Portishead Branch Line (MetroWest Phase 1)

9.23 ExA.ISH2.D4.V1 – Applicant's Oral Case and response to Representations at the Issue Specific Hearing 2 (ISH2)

Applicant's Oral Case and response to Representations at the Issue Specific Hearing 2 (ISH2) held on 11 January 2021 at 10am

Document Reference: 9.23 ExA.ISH2.D4.V1

Drawing
PORTISHEAD STATION CAR PARK
LAYOUT, LANDSCAPING AND NEW
BOULEVARD AND ACCESS PLAN
SHEET 2 OF 3

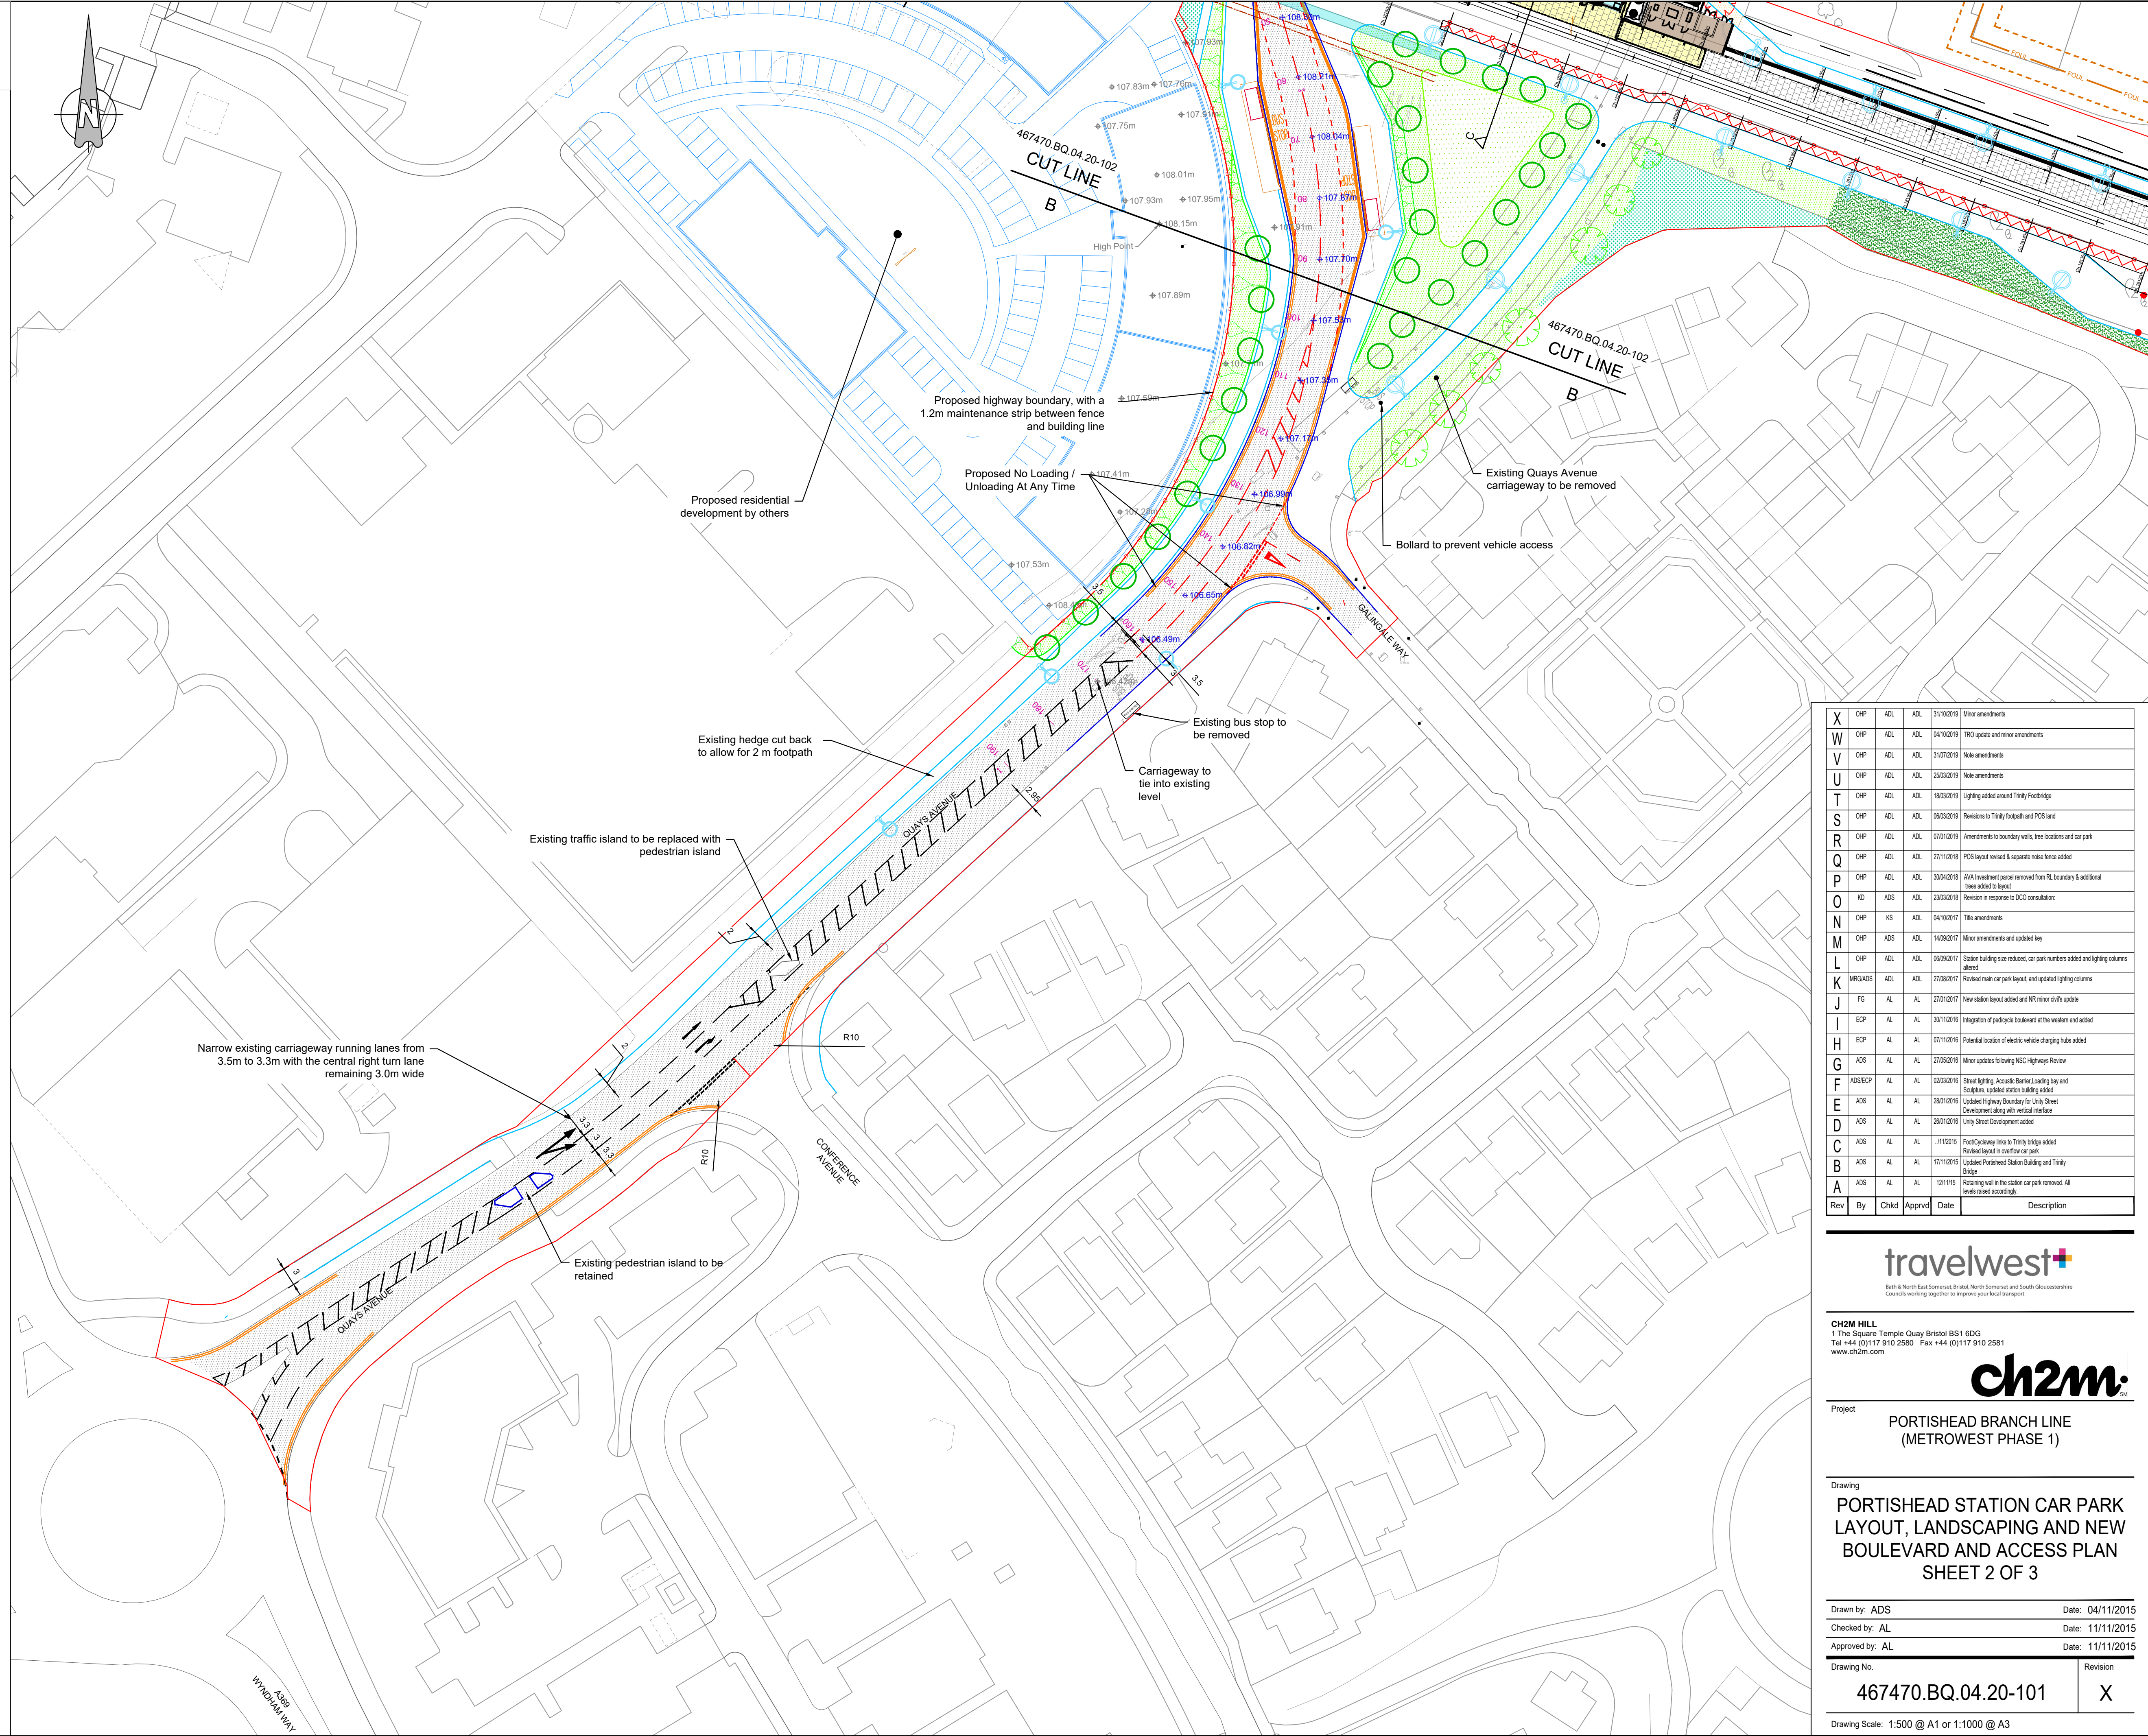
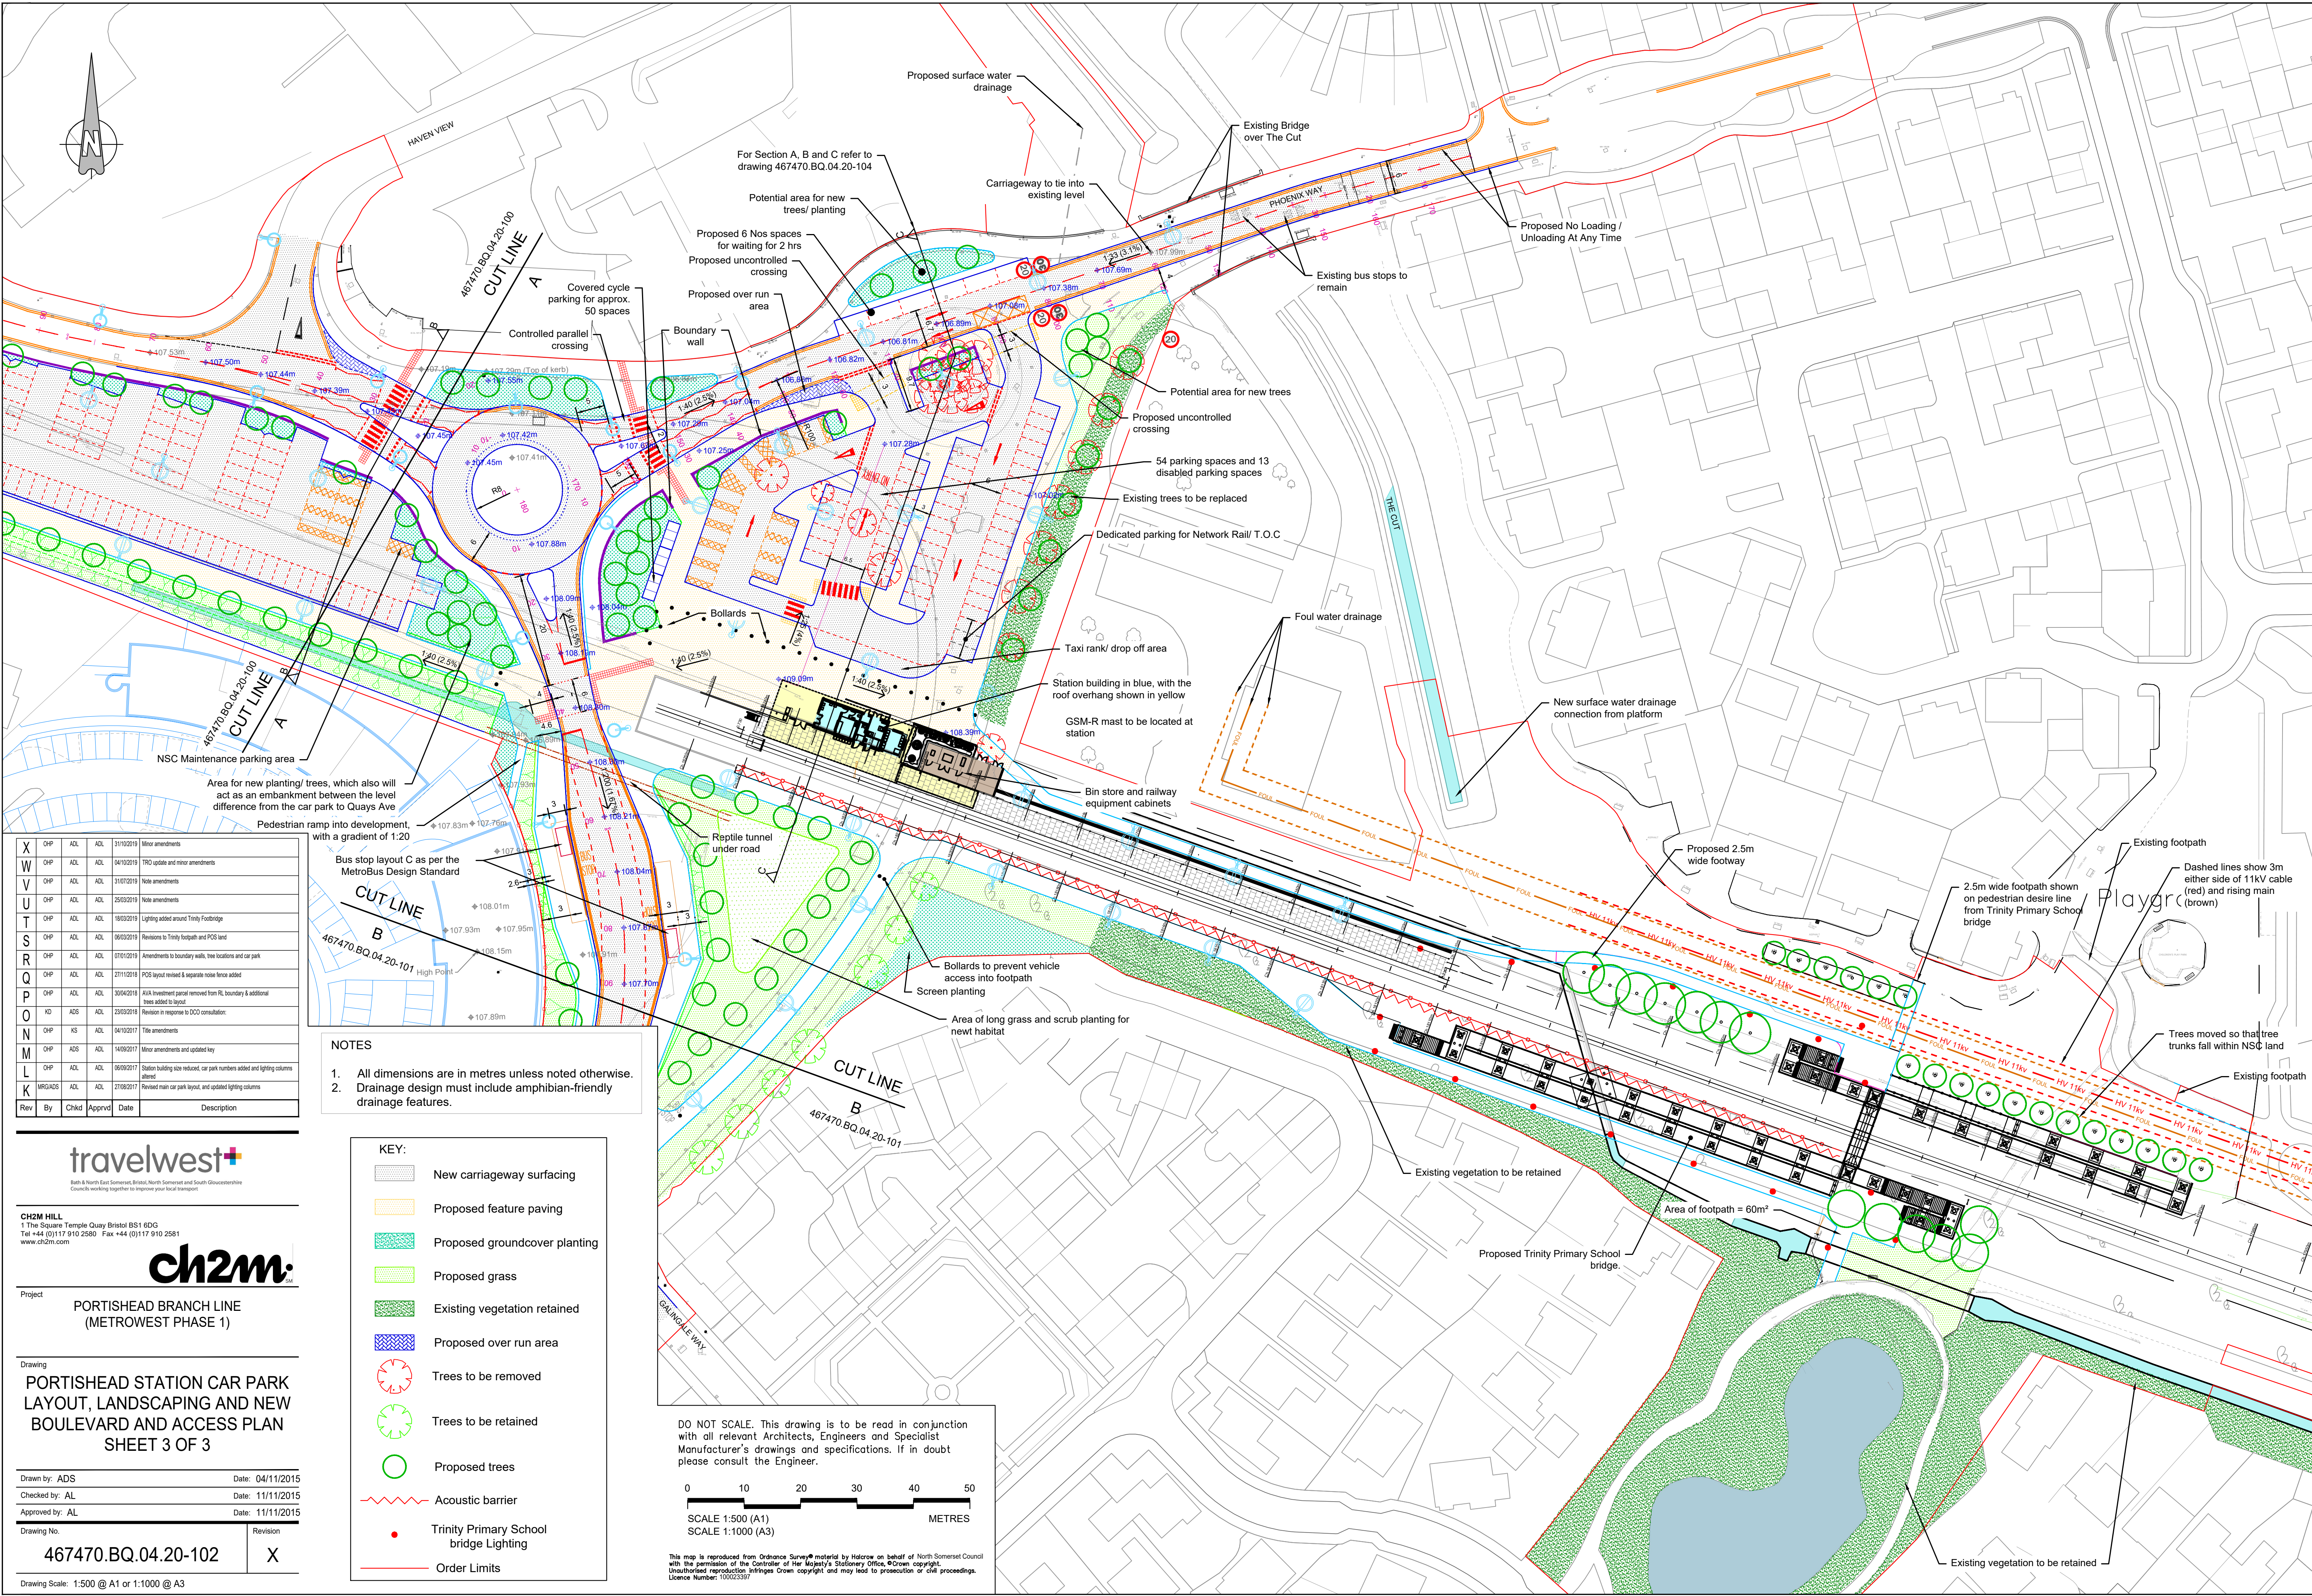
18.	ExA Panel	The ExA Panel asked whether there will be visual effects from the acoustic fence that is proposed alongside the former Portbury Station House and Peartree Field. Is there space for planting alongside these fences?	The Applicant stated that there is not much room in that area for planting. At Portishead Station, there will be separate acoustic and security fencing to secure the platforms. The Applicant has not specified the fence type and appearance, but has indicated the maximum height of the fences. The fencing at the Station House, Portbury will not be mounted on the former station platform. It will be on the trackbed between the railway and the former platform edge. In relation to noise modelling, the Applicant stated that this has assumed that the fence works as a noise barrier as a solid structure to reduce noise passing through it. The Applicant stated that the noise modelling assessed the noise barrier as located between the ex-platform and the new rails of sufficient height and acoustic properties to reduce the noise levels at the property to within acceptable levels. Extensive consultations have taken place with the relevant owners of the former Station house over several years. Initially the Applicant considered a separate security fence and an acoustic fence. Over time the owner was keen to push away the fence as much as possible from their land and as such the Applicant and owner have decided to have a combined security and acoustic fence. At the design	The acoustic fencing at Portishead Station is shown on the drawings within APP-038 Portishead Station Car Park Layout, Landscaping and New Boulevard and Access Plan (includes lighting for footpaths).

Ref	Comment/ Representation by:	Questions/Issues Raised at the ISH	Applicant's Response at the ISH	Applicant's Written Response
			stage the Applicant did put forward a number of options: the option settled on is a close-boarded wood fence. The ExA queried if this is shown in the plans and the Applicant responded that it would check and confirm.
